From:  Janice Chapman
Sent: 07 October 2014 14:51
To: [REDACTED]
Subject: BR/237/14/PL - Replacement windows at Flat 16 Carlingford Court, Victoria Drive, Bognor Regis

Existing window B - Bathroom
All panes are obscured glass

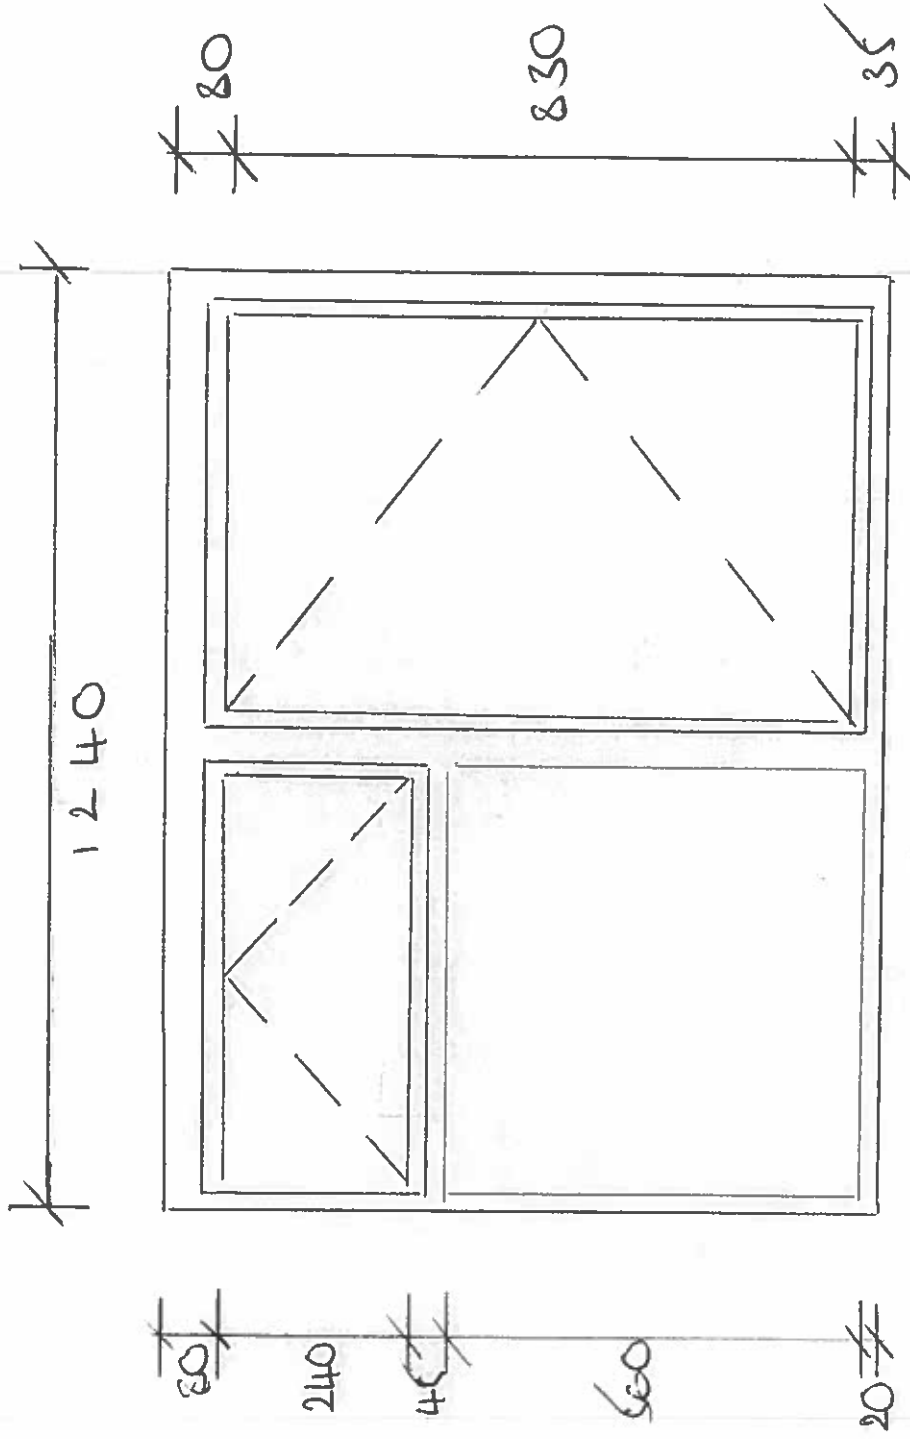
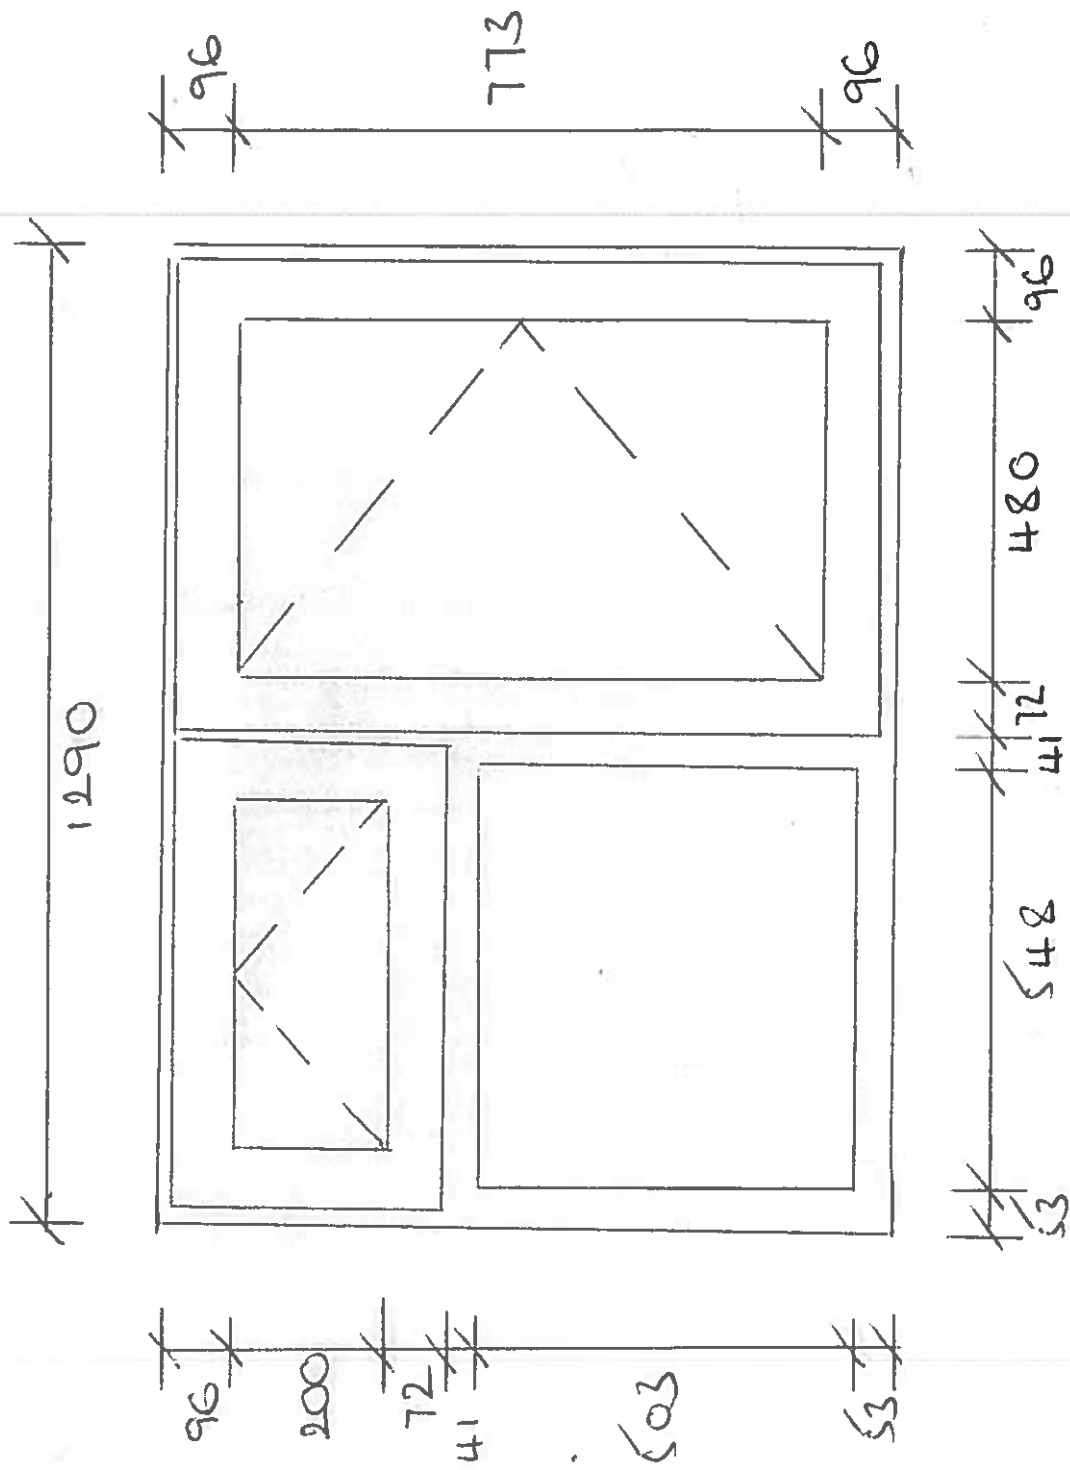
I have today visited the site and the proposed replacement windows and the drawings submitted showing the openings of the windows do not correspond with the existing openings and photos that have been submitted with the application.
